March 27, 2015

Ms. Helen Donaldson
Planning and Development Department
City of Portland, Maine
389 Congress Street
Portland, Maine 04101-3509

**Subject: Century Tire Plaza – 195 Kennebec Street
Project ID# 2015-027
Review Comments Received March 24, 2015**

SHEET TITLE: SITE LAYOUT AND UTILITY PLAN

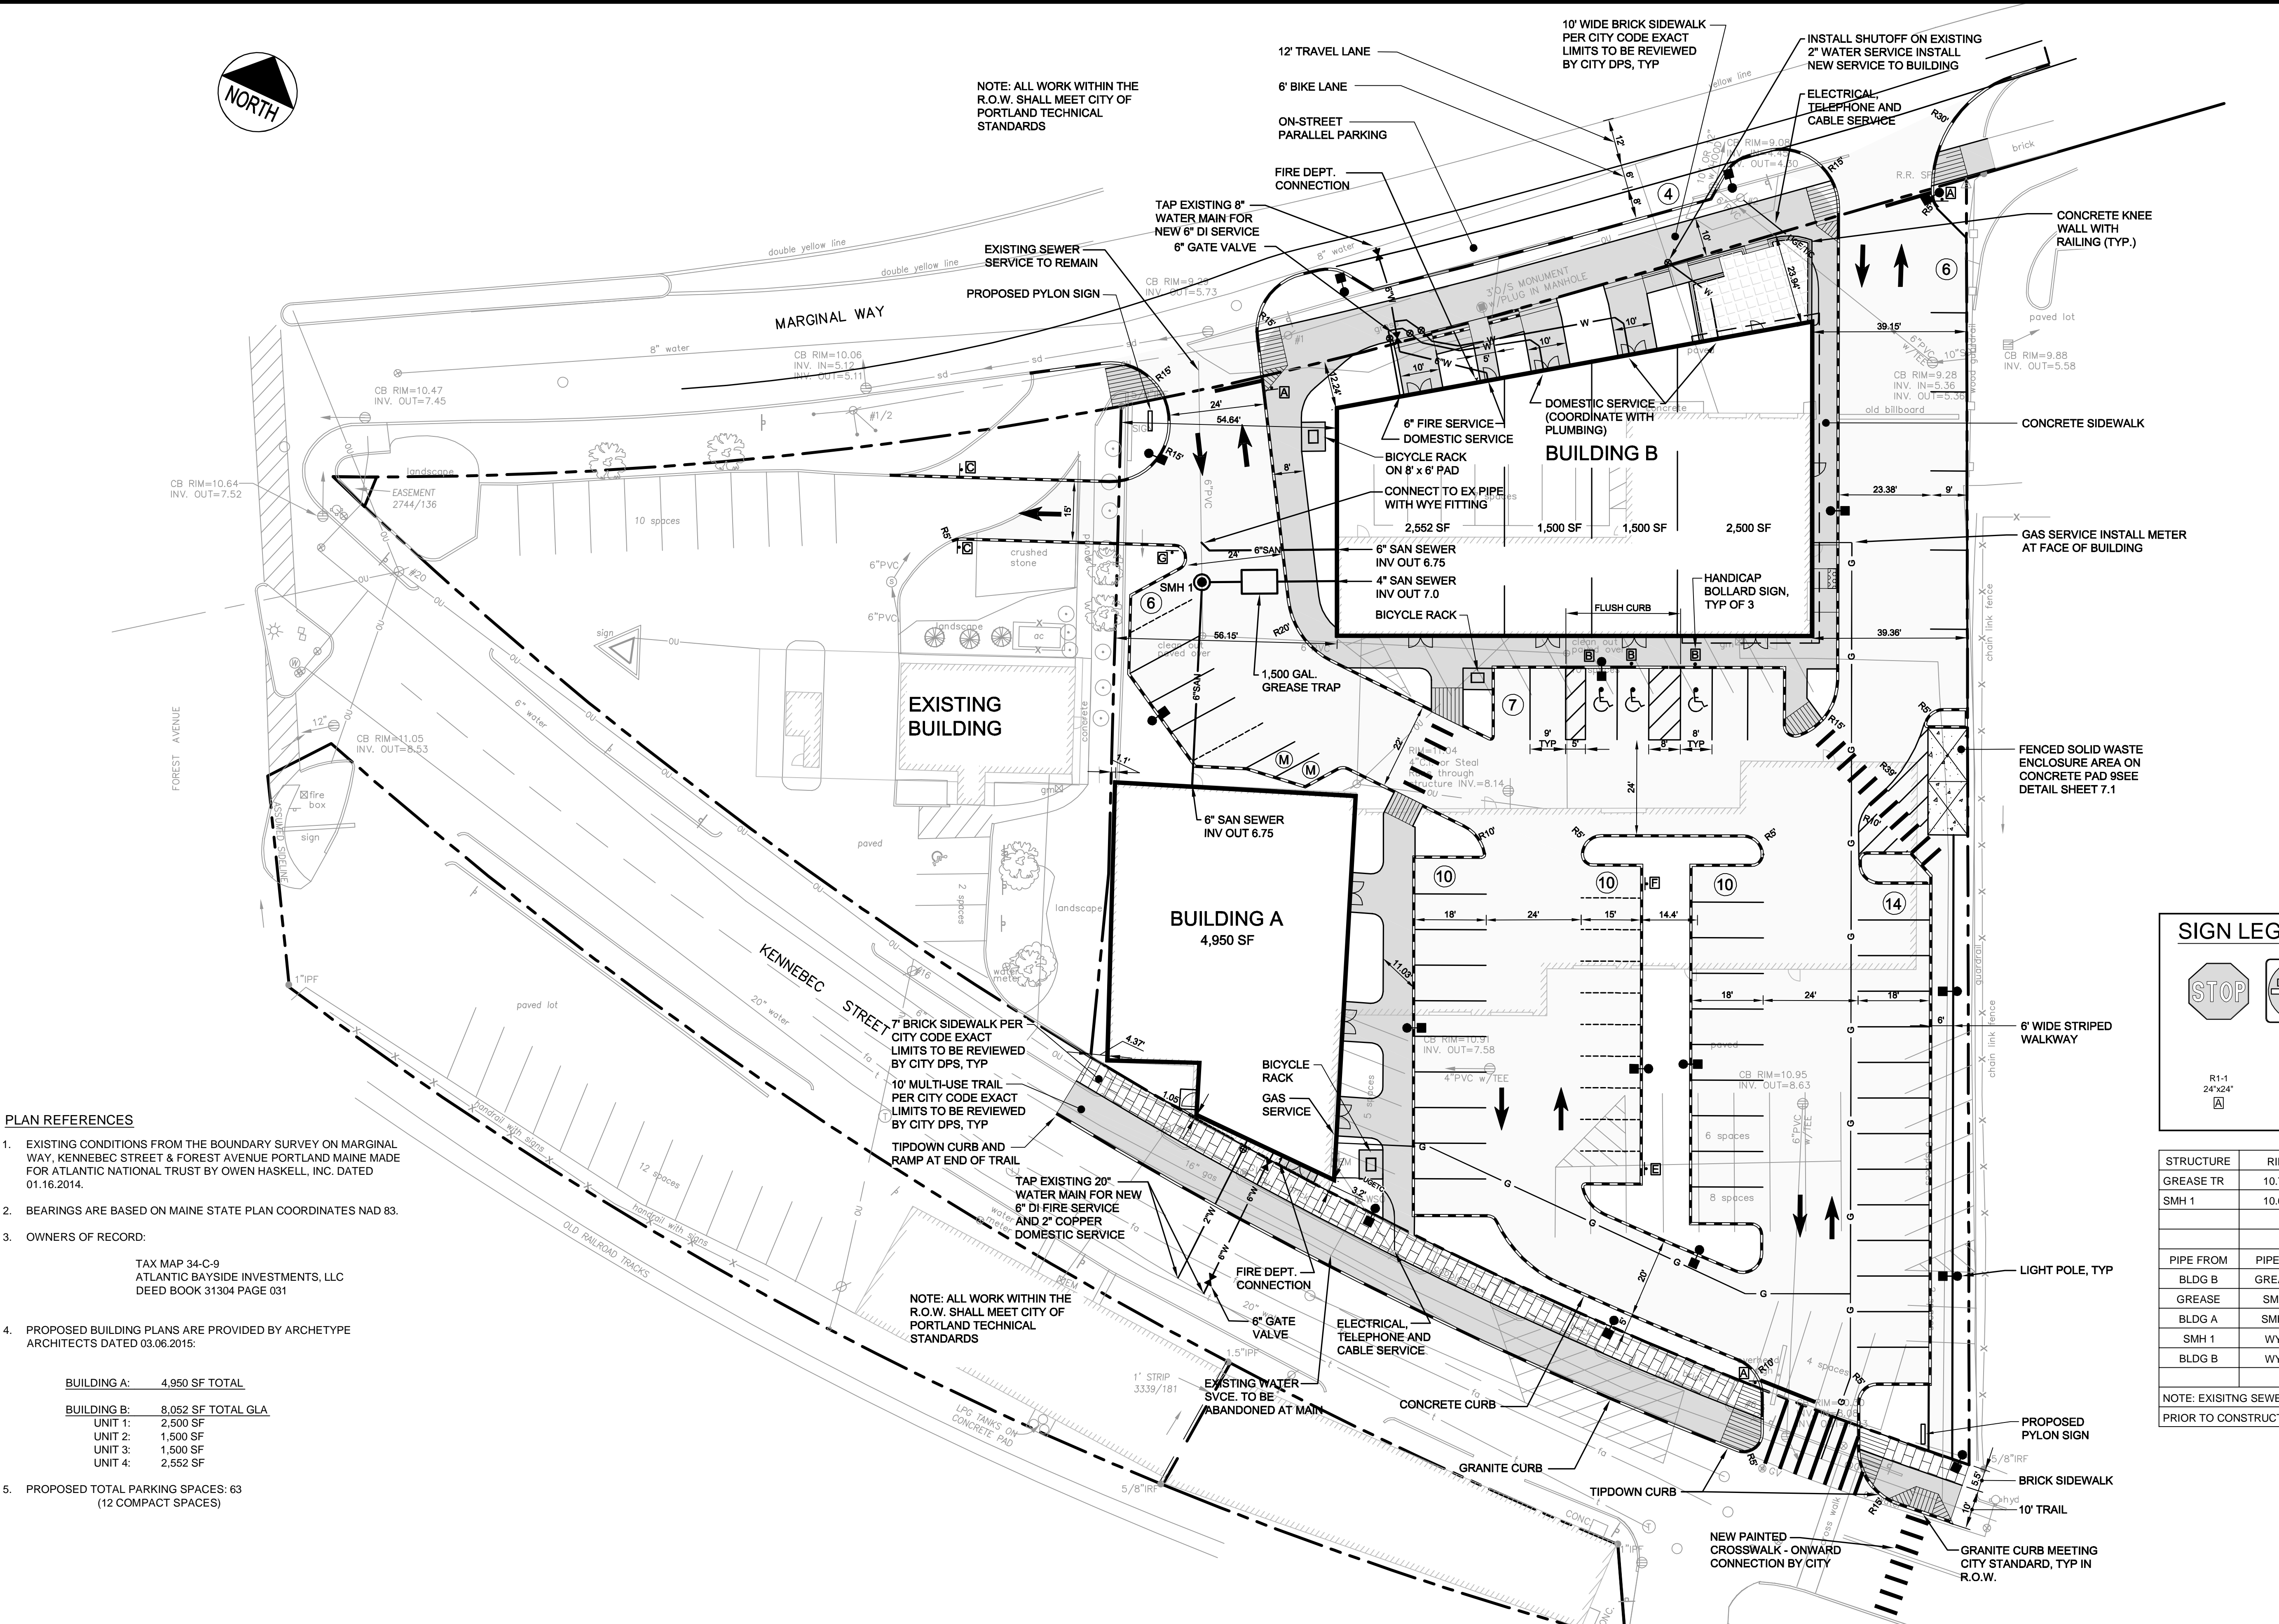
The project frontage on Marginal Way shall be adjusted to meet the design principles of the Marginal Way Master Plan (the nearby Gorham Savings Bank Building is a good example) . The plans should account for the following:

- On-street parking*
- The curb line should extend into Marginal Way and generally match the curb line at the Gorham Savings Bank site. The applicant should be cognizant of the transition from Forest Avenue and how vehicles will be aligned.*
- 10-foot brick sidewalk*
- 6-foot bicycle lane*

The frontage on Kennebec Street shall be adjusted to meet the design principles of the Somerset Street Extension project. The plans should account for the following:

- A 10-foot shared use bituminous path to be located next to the granite curb.*
- A 7-foot brick sidewalk along the property boundary.*
- On-street parking will not be permitted.*
- Transition of the shared use path to an on-road cycle track on both ends of the project will be required.*

The curbing material standard within the road right of way for the City of Portland is granite. Concrete is indicated on Kennebec St.

Stop bar locations shall be placed prior to sidewalk at the driveways.

Detectable warning panels are not required at driveways.

The Applicant proposes to install a new storm drain collection system for the majority of the site that will discharge to a catch basin connected to the combined sewer in Marginal Way. The Applicant proposes to preserve an existing Catch Basin "A" on the south side of the site, which connects to the Kennebec Street combined sewer system. The City anticipates installing a new, separated storm drain system in Marginal Way in the coming years; as such, the City requests that existing Catch Basin "A" be connected into the proposed system discharging to Marginal Way.

Since Marginal Way will have a new separated stormwater system in the near future, is it possible to convey drainage from existing CB A to proposed CB 1 and abandon lateral from existing CB A to CB with a rim of 10.30 in Kennebec St.?

The plans have been revised to show the requested curb line revisions and the addition of on-street parking, and a six-foot wide bike lane on Marginal Way. Striping has been added to delineate the bike lane.

The revised plans show the requested configuration on Kennebec Street, with the shared use path at the curb line and the brick sidewalk at the outside of the Right-of-Way. It should be noted that this is opposite to the configuration shown in the Somerset Street Extension Feasibility Study, dated January 2015. The multi-use trail transitions onto the existing street at the western end, as requested in the review comment above. The Design Engineer and the Applicant have significant concerns regarding the safety of this configuration. The end of the multi-use trail will potentially direct bicycle users onto the street directly opposing the current one-way traffic direction, and immediately adjacent to the heavily used exit to the Enterprise Rental facility. The trail configuration, and relationship to the adjacent site will need careful thought in order that a safe and efficient travel corridor is provided for all street users and to maintain the existing use, and future development potential for the adjacent property.

The label for the proposed curbing material has been changed to indicate granite curbing at this location.

Stop bar locations have been revised in response to this comment and the warning pavers have been removed.

The plans have been revised to show connection of the piping from Catch Basin A (now a new catch basin structure) to New Catch Basin 3, and hence to the system on Marginal Way, as requested.

The plans have been revised to show connection of the piping from Catch Basin A (now a new catch basin structure) to New Catch Basin 3, and hence to the system on Marginal Way, as requested.

**2 | BUILDING A SOUTH ELEVATION**  
 1/8" = 1'-0"

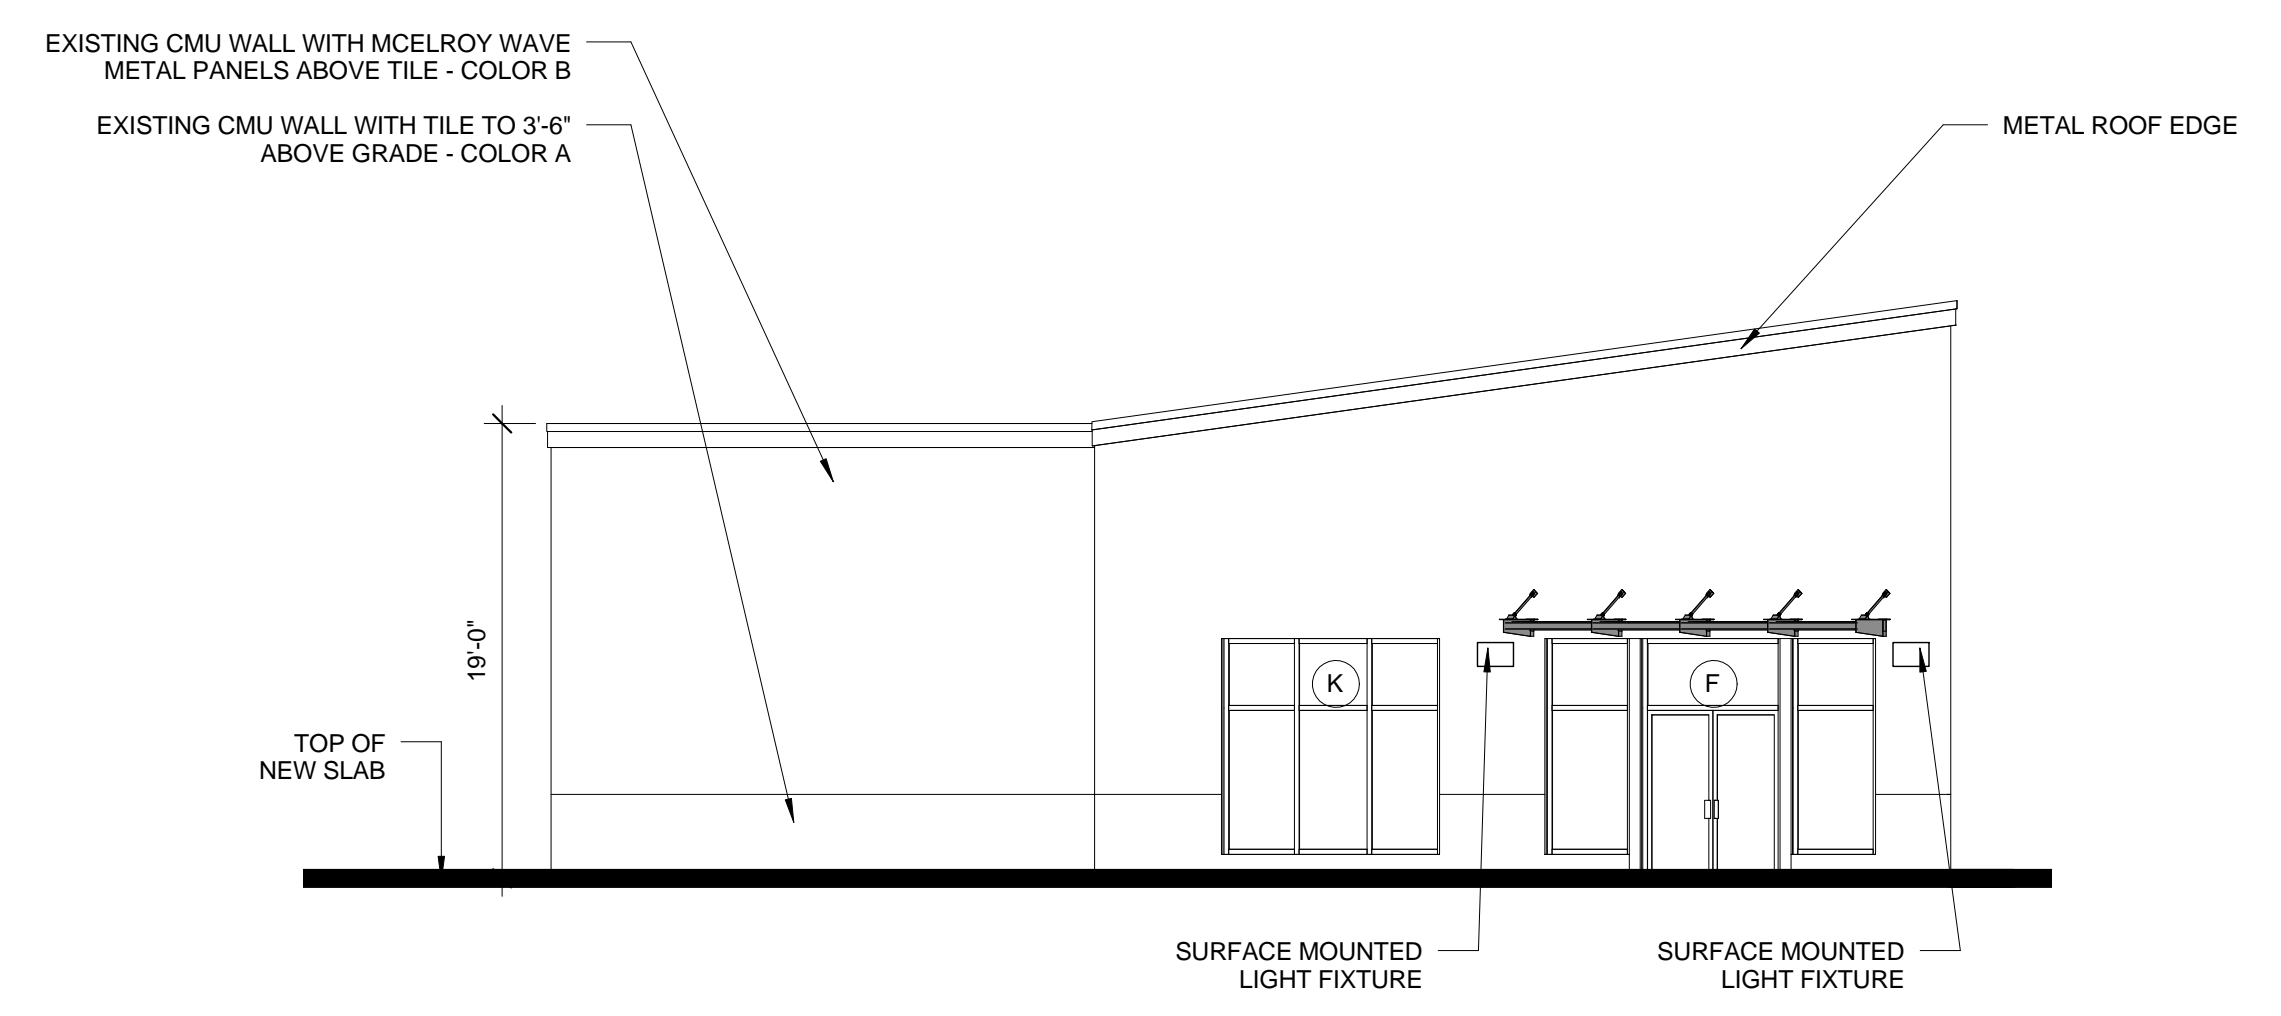
- *Building A South Elevation, which faces Kennebec Street, should be revised to provide windows.*

This was discussed at the meeting on March 25, 2015 and the plans for Building A have been amended to show a revised façade and an entry on Kennebec Street.
